20 February, 2012.

**RE: COUNCIL SUBMISSION TO MP10\_0177 MOD 7, APPLICATION FOR MODIFICATION OF MAJOR PROJECT APPROVAL UNDER SECTION 75W, 14 -18 BOONDAH ROAD, WARRIEWOOD**

I refer to Council's letter dated the 7 February 2012 in relation to the above modification that is to permit staged strata subdivision of the development currently under construction on the site.

CARPARK LEVEL

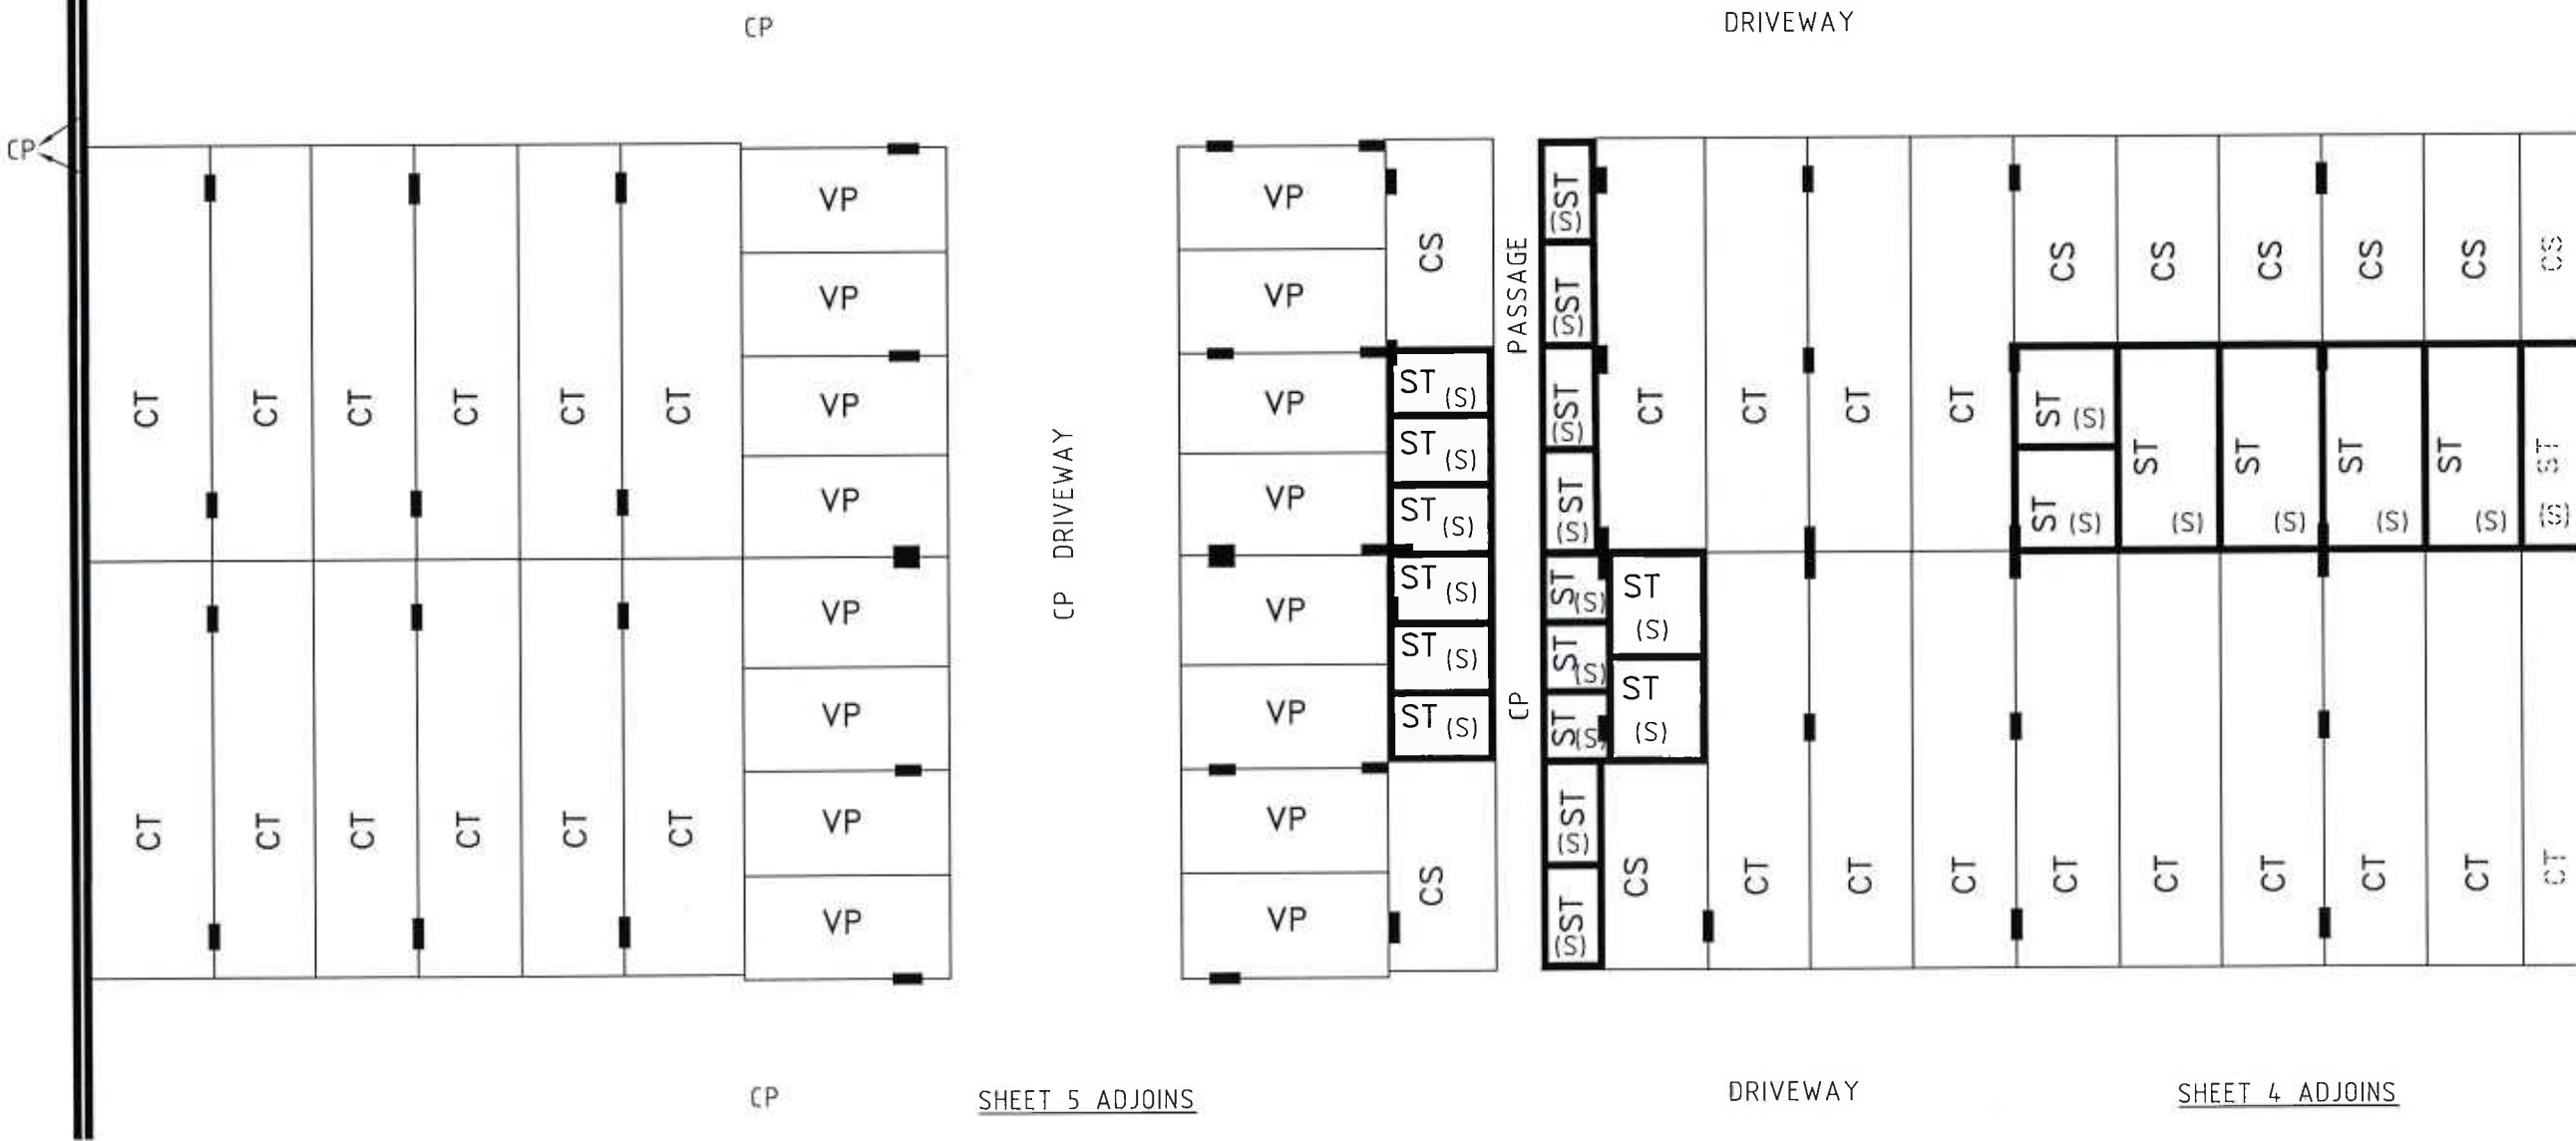
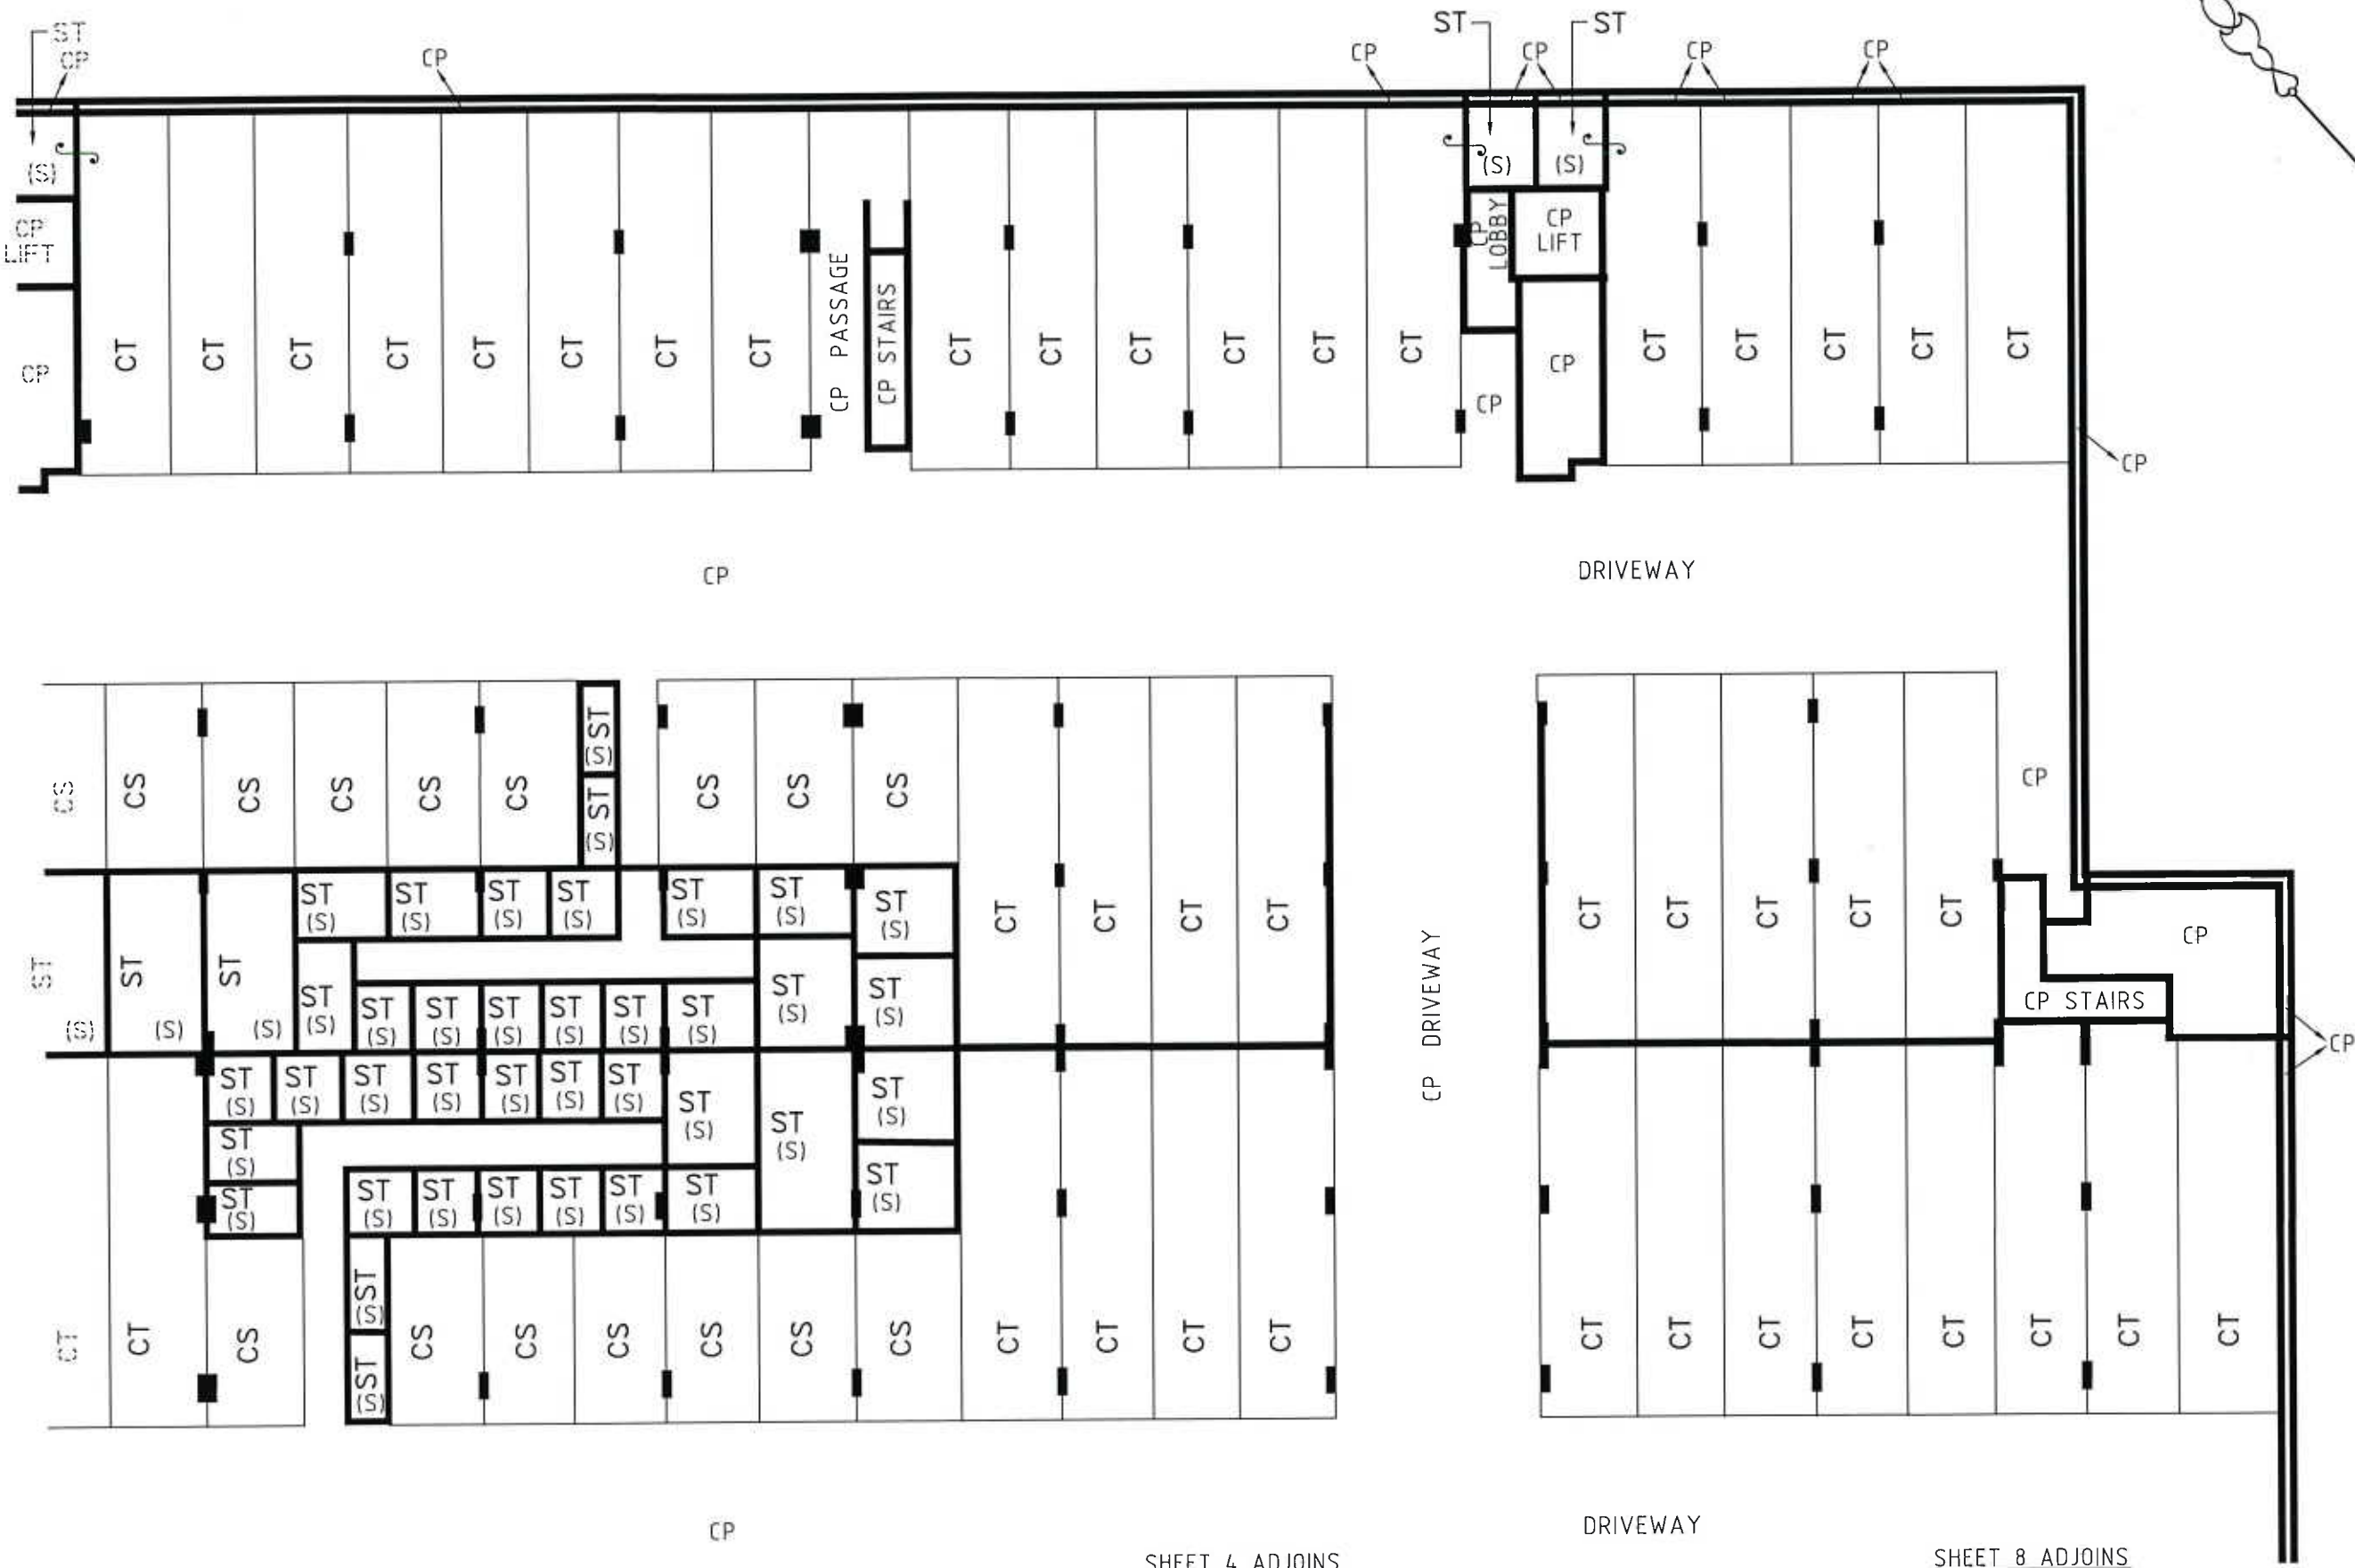
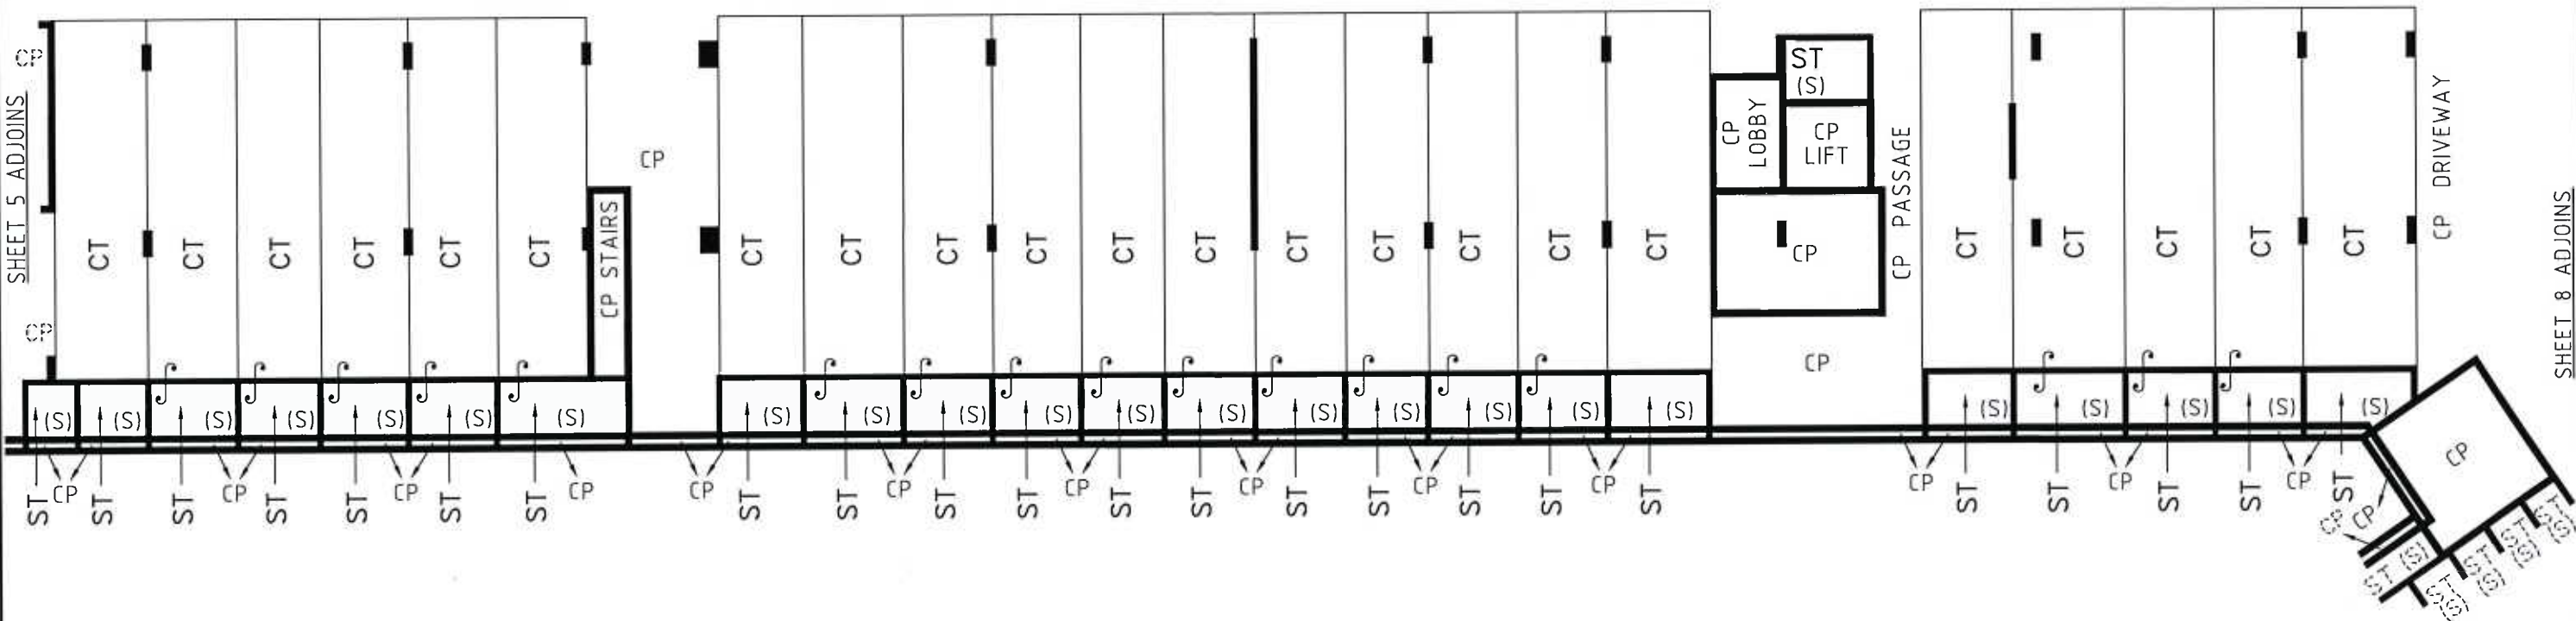
- a) ***Each dwelling being provided with a car parking space(s) commensurate with the number of bedrooms contained in the dwelling and storage area within the single level basement in accordance with Condition B3 (as amended). The 46 visitor parking spaces, spaces for emergency and delivery vehicles and a space for car washing, and bicycles spaces are not allocated to individual dwellings through the subdivision and must be “Common Property” readily available for use.***

***Any future strata subdivision of the subject site must respect the car parking and storage area allocation approved in accordance with Condition B13. Prior to the release of the approved linen plan subdivision, the parking spaces (with the exception of the 46 visitor parking spaces) and storage areas in the single level basement are to be allocated to each dwelling, to be shown as Part Lot rather than individual lots in the linen plan. The remainder of the basement parking level comprising 46 visitor parking spaces, spaces for emergency and delivery vehicles and area for car washing, bicycle spaces, garbage areas, vehicular ramps etc. to be shown as 'Common Property' and must not be individually allocated by the subdivision or any by-law or other mechanism.***

***Prior to the release of the approved linen plan of subdivision, a restrictive covenant is to be created to the effect that the residential and visitor parking spaces including spaces for emergency and delivery vehicles and car washing are not to be used in a manner inconsistent with the Project Approval (as amended). The covenant is to be created appurtenant to, at no cost to and to the satisfaction of Council and shall include a condition that the covenant cannot be varied, modified or released without the prior approval of Pittwater Council. The covenant is to be lodged with the Land and Property Information Office at the same time as the linen plan of subdivision is lodged. Any future strata subdivision of the site is to include a restriction on user burdening all utility car parking allotments in the strata plan and/or an appropriate restrictive covenant burdening all car parking part-lots in the strata scheme.***

**Response:** The first sentence in the above condition is contrary to the number of car parking spaces approved by the PAC and is not in accordance with Council's own DCP21. Car parking was approved on the following basis:

Were the above condition to be approved in the proposed form, the condition could be read that a 3 bedroom unit would be required to have 3 car spaces, which I do not believe is Council's intention. The basement car park has been built and there is no area to provide more car parking spaces.

Condition B13 (as amended) already imposes car parking requirements as approved by the PAC. There is no need for further conditions which repeat the same outcome. Therefore the condition proposed by Council should be amended as follows:

**Response:** Council is seeking a restrictive covenant to be placed on the title for all vehicle parking within the basement, including the shared delivery/garbage space at ground level. This is extremely onerous and such a condition has not been experienced by Meriton from any other council or other PAC determination involving a residential flat building development. The above proposed part condition should therefore be deleted.

The strata plan lodged with the Department of Planning has resident car parking in Part lots as required. The strata subdivision will also have visitor spaces, emergency spaces, car wash bay and the shared deliver/garbage collection space in common property. This is standard practise for strata title of common property and basement car parking. A condition reflecting this can be imposed.

Car spaces required to be retained in common ownership can be titled on the strata plan. For example, the emergency spaces will be marked "emergency car space" on the title. In addition the emergency car spaces in common ownership will also be marked on site "Emergency Car Space".
